LAND AT NW BICESTER LOCAL CENTRE
APPLICATION REFERENCE: 19/01036/F

We have therefore updated the plans to reflect the very minor alterations required to achieve this separation. The enclosed plans are set out below, together with a summary of the now superseded plans:

2 South Elevation - Street Elevation
1 : 200

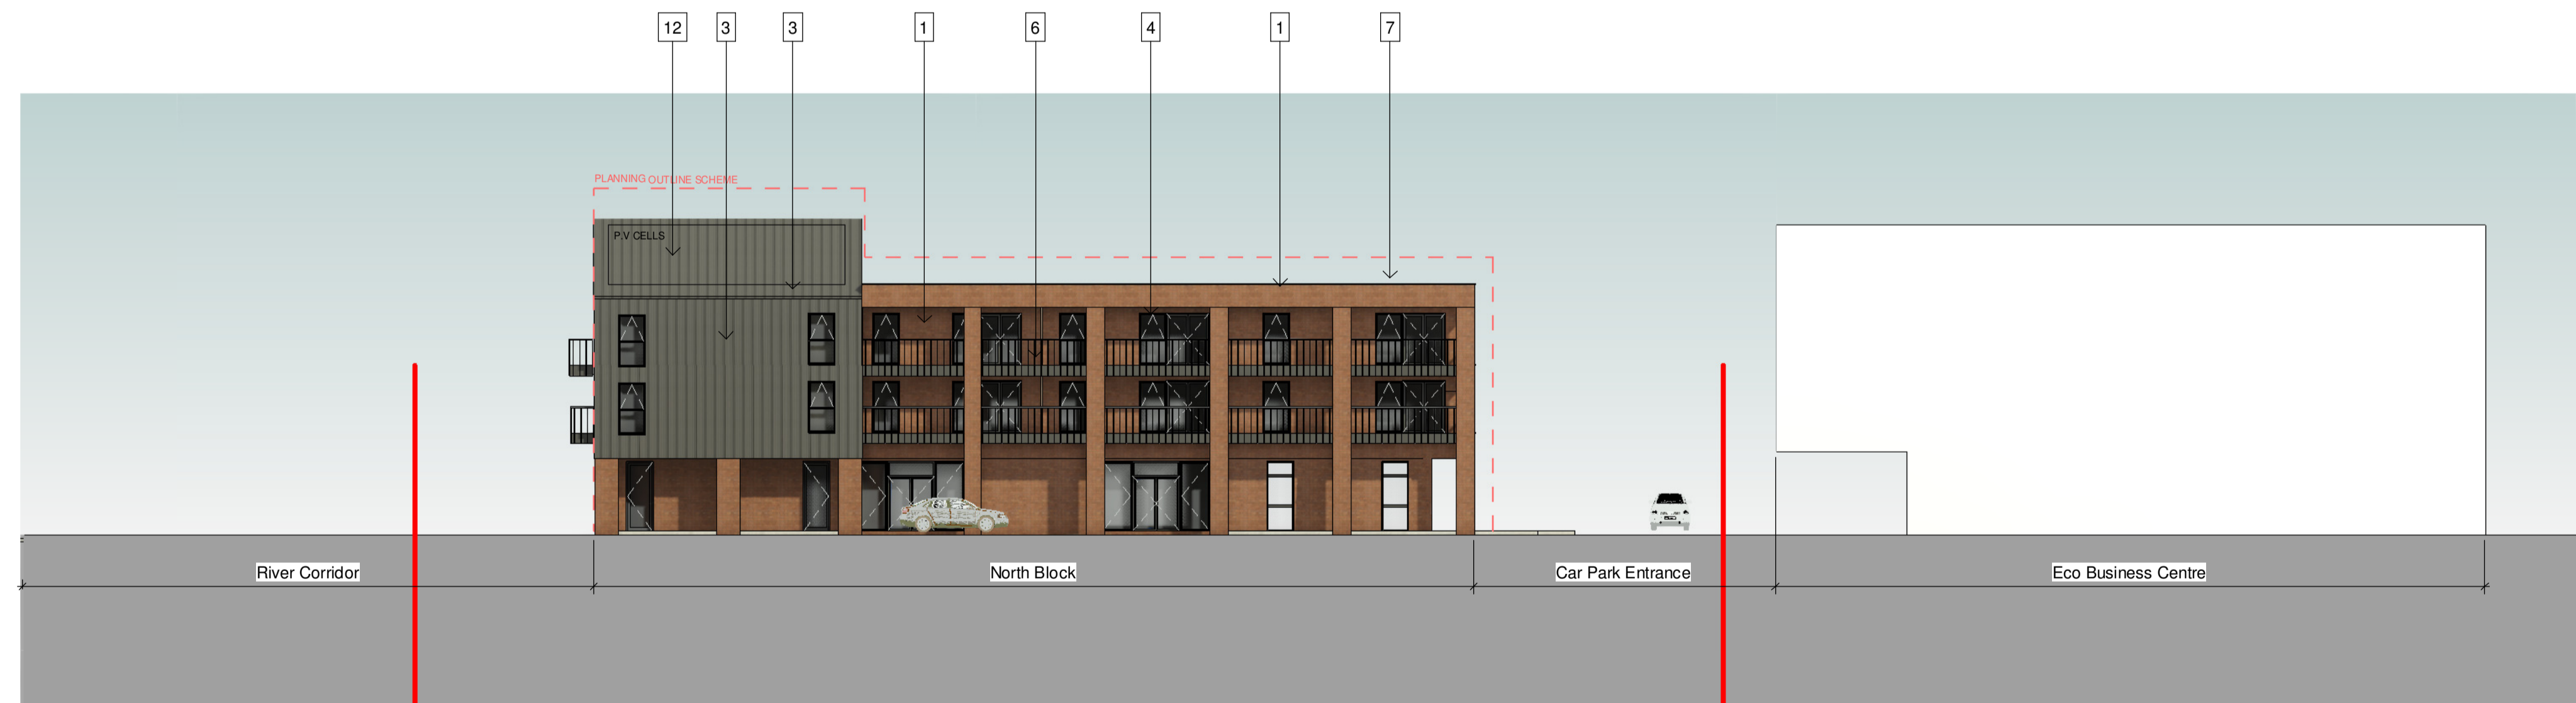
1. A separate access from the street has been provided for the café;
2. The position of the proposed community hub access has been moved west slightly so that it is not too close to the new proposed café entrance; and
3. The door that was previously shown between the small community room and the café space has been removed.
